## Engineers Comments Regarding Surface Water Drainage

| <b>Application Reference:</b>   | WA/11/25/DOC                                                                                                        | <b>Reviewer Reference:</b> | ADC/PC     |
| <b>Site Name:</b>               | Snetterton West Walberton Lane Walberton BN18 0QS                                                                   |                            |            |
| <b>Application Description:</b> | Approval of details reserved by condition imposed under WA/46/22/HH relating to condition 3-surface water drainage. |                            |            |

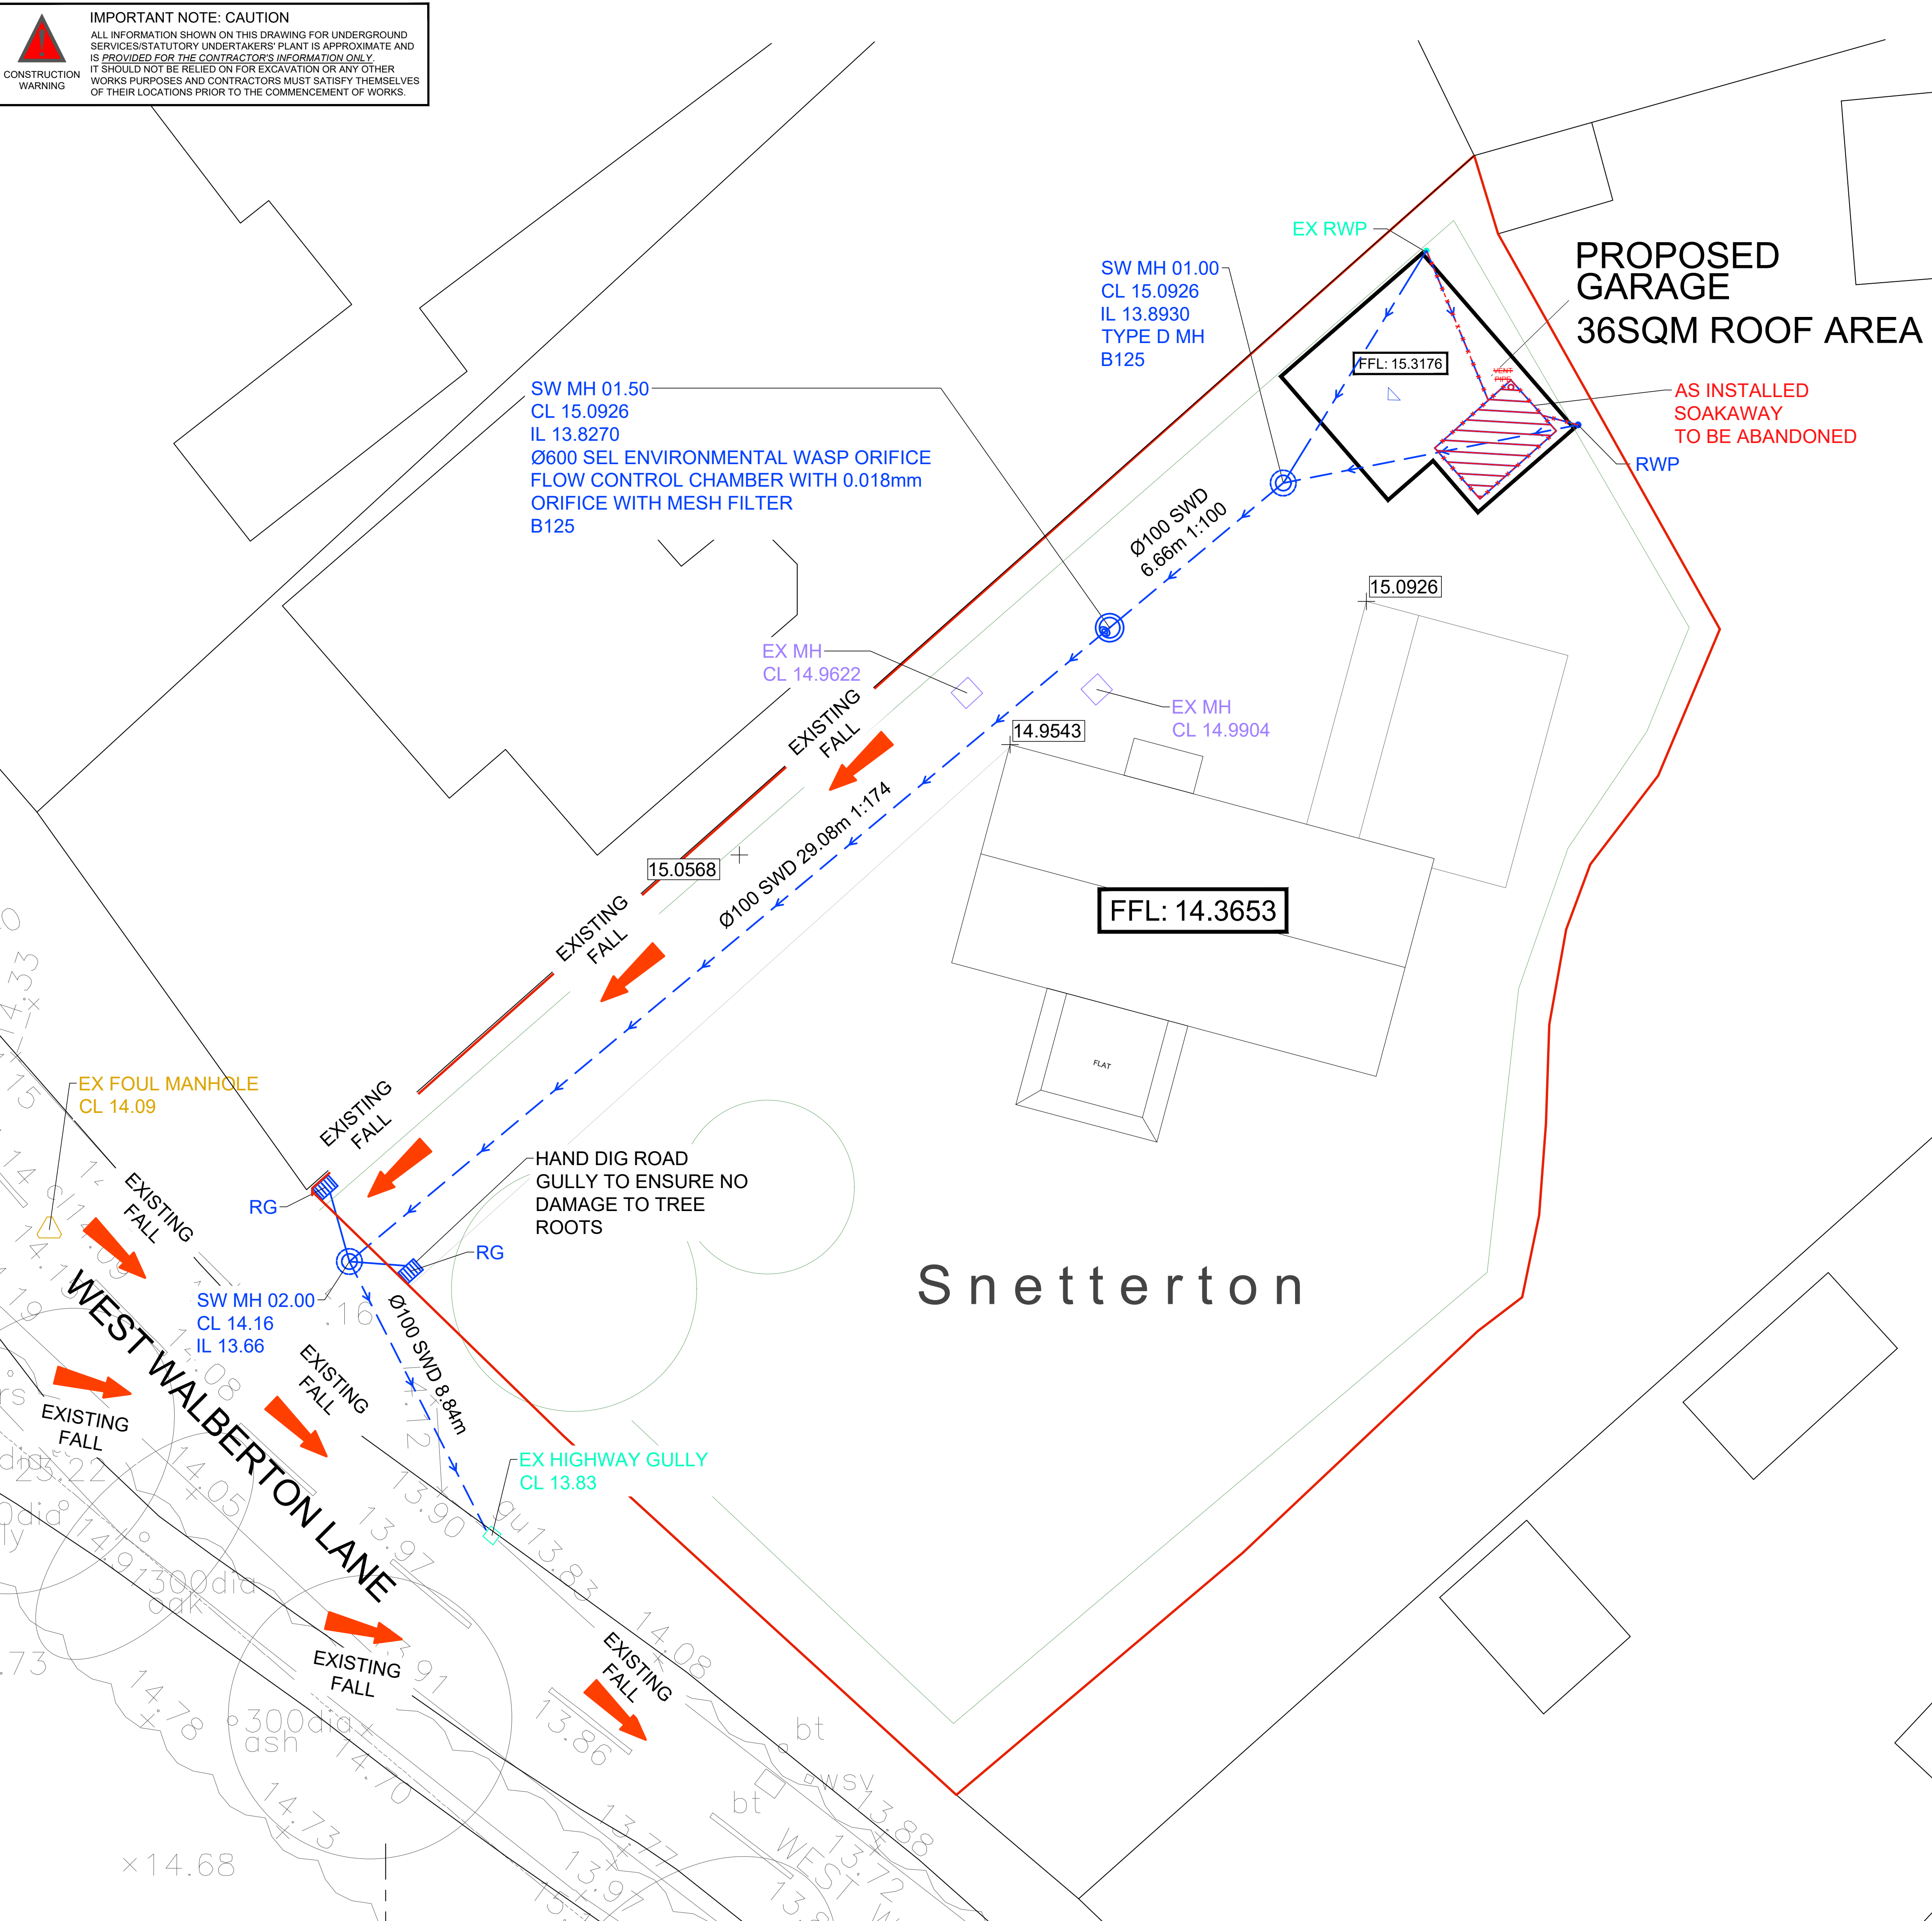
|                     | ADC Drainage Comments                                                                                                                                                                                                                                                                                                                                                                                                                                                                                                                          | ADC Further Comment                                                                                                                                                                       | ADC Further Comment                                                                                                                                                                                                                                                                                                                     | Designer Comments                                                                                                                                                                                                                                        | ADC Further Comment                                                                                                                                                                                                                                                                                                                  |
|---------------------|------------------------------------------------------------------------------------------------------------------------------------------------------------------------------------------------------------------------------------------------------------------------------------------------------------------------------------------------------------------------------------------------------------------------------------------------------------------------------------------------------------------------------------------------|-------------------------------------------------------------------------------------------------------------------------------------------------------------------------------------------|-----------------------------------------------------------------------------------------------------------------------------------------------------------------------------------------------------------------------------------------------------------------------------------------------------------------------------------------|----------------------------------------------------------------------------------------------------------------------------------------------------------------------------------------------------------------------------------------------------------|--------------------------------------------------------------------------------------------------------------------------------------------------------------------------------------------------------------------------------------------------------------------------------------------------------------------------------------|
| 5.                  | Please submit any relevant investigations into the highway drainage network – particularly the levels at connection.                                                                                                                                                                                                                                                                                                                                                                                                                           | Not submitted.                                                                                                                                                                            | If the connection is being made to an 'online' road gully, please provide details of the existing inlet outlet pipes (ie. configuration, diameter and invert levels). Specify the 100mm diameter pipe connection level (needs to achieve soffit to soffit) and gradient. If this is not an 'online road gully, then the connection will | The existing road gully has been inspected, it is an off line gully with outlet 550mm below ground level. The connection from the site will be made to the outgoing pipe outside of the road gully and a will be inspected and approved by WSCC Highways | I have spoken to WSCC who have in turn contacted the applicant. Essentially, the proposed point of connection is not acceptable and the connection will need to be made to the existing road gully, which will need to be rebuilt in the form of a catchpit manhole with grated cover. A soffit to soffit connection will need to be |

|    |                                                                                                                            |                                                                                                                                                                                                                                                                                                                                                                                                                                                  | need to be made at a more suitable location and in an agreed method.                                                                                                                                                                                                                                                                                                                                                                                                                                                                                                                                                                                                                                                                                                                                                                                                                                                                                                                                                                                                                     |                                                                                                                                                                                                                                                                                                                                                                                                                                       | <p>achieved. As a result, the bend outside SW MH 02.00 will be even tighter, and therefore the arrangement will need to be adjusted – a suggestion would be to make the southern most proposed road gully a catchpit manhole with grated cover, and use this to provide the outlet towards the WSCC system.</p> <p>The connection details to the highway drainage system will need to be detailed and formally agreed with WSCC. Drawings to be updated to include all the relevant agreed details and evidence provided to confirm that WSCC have approved them.</p>               |

| 14. | Further detail is required on the drainage layout – please refer to attached checklist.                                                                                                              | The design requires amendment as per point 2. Invert levels not provided for SW MH 01.00 No levels or dimensions provided for the tank.                                                                                                                                                                  | No attenuation tank currently proposed.                                                                                                                                                                                                                                | N/A                                                                                                                                                            | Noted. Comment closed.                                                                                                                                                                                                                                                     |
| 15. | Construction detail drawings are required for all drainage components – please refer to attached checklist.                                                                                          | Unaddressed.                                                                                                                                                                                                                                                                                             | Unaddressed.                                                                                                                                                                                                                                                           | Details sheet provided                                                                                                                                         | <p>Please include outlet pipe diameter on proposed road gully construction details.</p> <p>Specify overflow level in flow control chamber.</p>                                                                                                                             |
| 16. |                                                                                                                                                                                                      |                                                                                                                                                                                                                                                                                                          | The gradient of pipe length SWMH 01.50 to 02.00 is slacker than the minimum permissible gradient for a 100mm pipe. A minimum 1 in 100 gradient or steeper must be achieved.                                                                                            | Gradient amended to 1:100                                                                                                                                      | Noted. Comment closed.                                                                                                                                                                                                                                                     |
| 17. |                                                                                                                                                                                                      |                                                                                                                                                                                                                                                                                                          | The proposed surface water drain is shown running between two existing manholes adjacent the house. Assuming these relate to existing foul drainage, please provide details ie. pipework configuration, diameters, invert levels). This is to ensure that the proposed | Inverts of foul drainage added, the proposed surface water run is deep than the existing foul drainage so there is no clash                                    | Noted. Comment closed.                                                                                                                                                                                                                                                     |

| 20. |  |  | Proposed manhole SW MH 02.00 may be located in public highway. Please provide evidence that this is acceptable to WSCC.                                                                                                                                                                                                 | This has been moved to the end of the drive                                                                                                      | Noted but see comment no.5. Comment closed.                                                                                                                                                                                                                                                                                                |
| 21. |  |  | The proposed road gully directly east of MH SW 02.00 is connecting against the flow in the pipeline and will need to be reconfigured.                                                                                                                                                                                   | This has been resolved with a standard 450 dia radius on the outlet pipe so that the PPIC can be oriented to have the gullies coming in the side | Noted but see comment no.5. Comment closed.                                                                                                                                                                                                                                                                                                |
| 22. |  |  | Specify proposed discharge rate on drainage layout plan.                                                                                                                                                                                                                                                                | Added to plan                                                                                                                                    | Noted. Comment closed.                                                                                                                                                                                                                                                                                                                     |
| 24. |  |  |                                                                                                                                                                                                                                                                                                                         |                                                                                                                                                  | Upstream of SW MH 01.00, where there are rodding eye arrangements. Please either replace this arrangement with new manholes at the points of redirection or show the rodding eye arrangement more clearly ie. indicate the pipes downstream of the RWP's connecting just downstream of the rodding points via oblique 45 degree junctions. |
